DECISION DELEGATED TO DEVELOPMENT MANAGER

Application No:	H07-0885-19	Applicant:	Mr & Mrs D Jones
Proposal:	Garage conversion to residential use		
Location:	1 Sycamore View Gedney Hill Spalding		
Terminal Date:	1st January 2020

FLOOR PLAN - PROPOSED
ELEVATIONS - PROPOSED
LOCATION PLAN

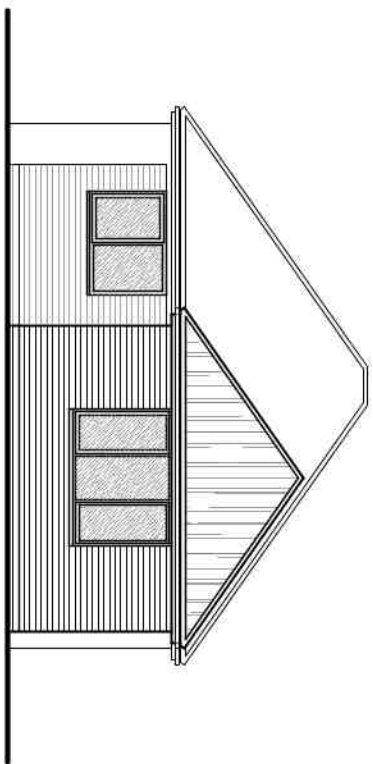
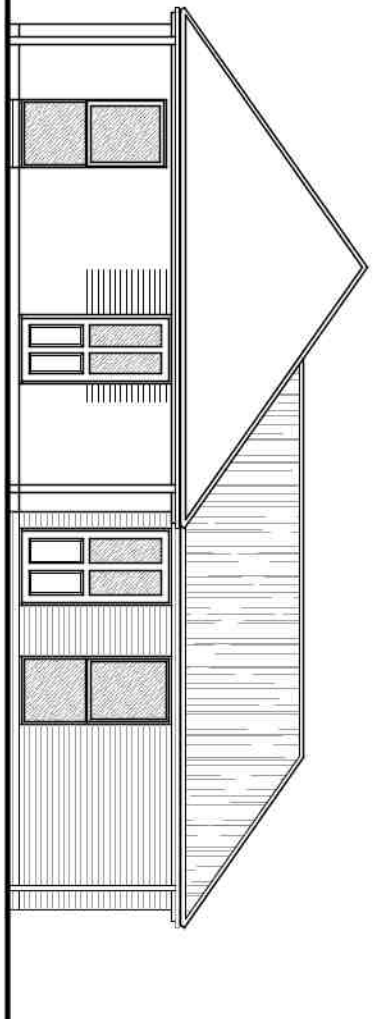
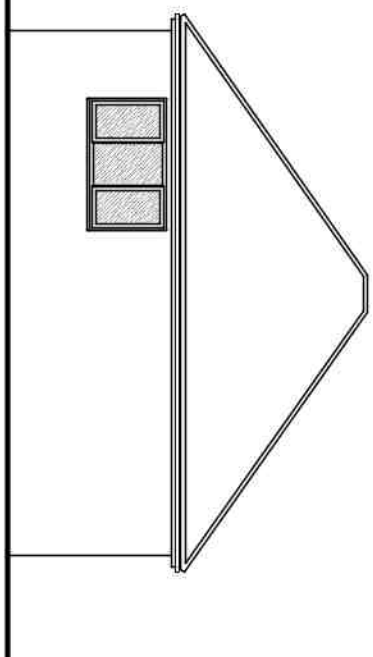
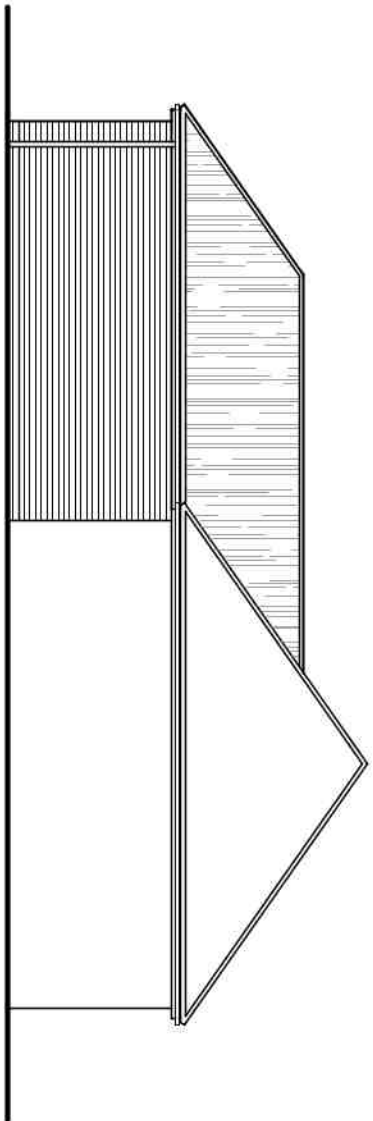
The existing garage is a hip roofed detached building. The proposed extension of the garage would be subservient to the building in terms of scale, mass and bulk.

For a single-storey dwelling with two bedrooms accommodating 3 bed spaces, the DCLG standards set out a minimum gross internal floor area (GIFA) of 61 square metres. The proposed GIFA is approximately 55 square metres, which is clearly less than the nationally described standard. This is further evidence of the cramped nature of the proposed development.

SITE PLAN 1:500

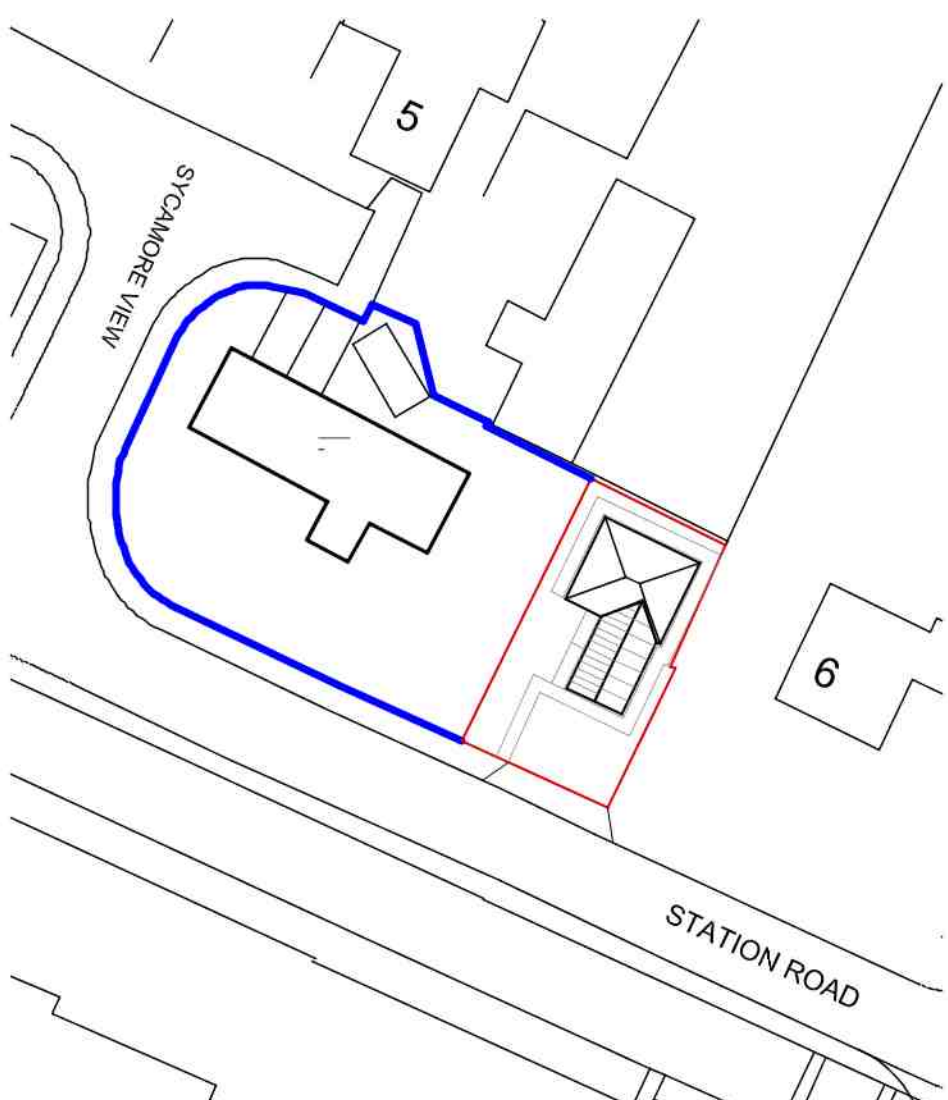
The enlargement would not compromise car parking provision. The submitted site plans shows that 3 car parking spaces could be achieved for 1 Sycamore View and the proposed new dwelling would have 2 spaces to the front. The provision of car parking space therefore complies with the minimum requirements contained in Appendix 6 of the SELLP.

However, although there are some positive aspects, it is considered that the proposal would represent a cramped form of development that is out of keeping with the character of existing development in the locality. Other dwellings in the area are on visibly larger plots than the application site. No. 3 Station Road, which appears to currently be the smallest plot in the vicinity, although sitting within a similar width plot, is approximately 6.7m deeper than the application site. That dwelling therefore does not appear cramped within its plot.

However, the domestic garden of the proposed dwelling would not be sufficiently spacious to allow the future house occupiers to enjoy a good standard of amenity. The external amenity area would comprise narrow strips of lawn surrounding the dwelling as well as a patio area adjacent to the south-western elevation. By reason of their nature, the shrubs, paved paths and drive are excluded from this consideration as they do not provide functional amenity space. The hedge which is

proposed to remain would also restrict the functional space. It is considered that this would result in material harm to the amenity standards of future residents to the extent that it cannot outweigh any other strength of the proposal on the grounds of residential amenity.
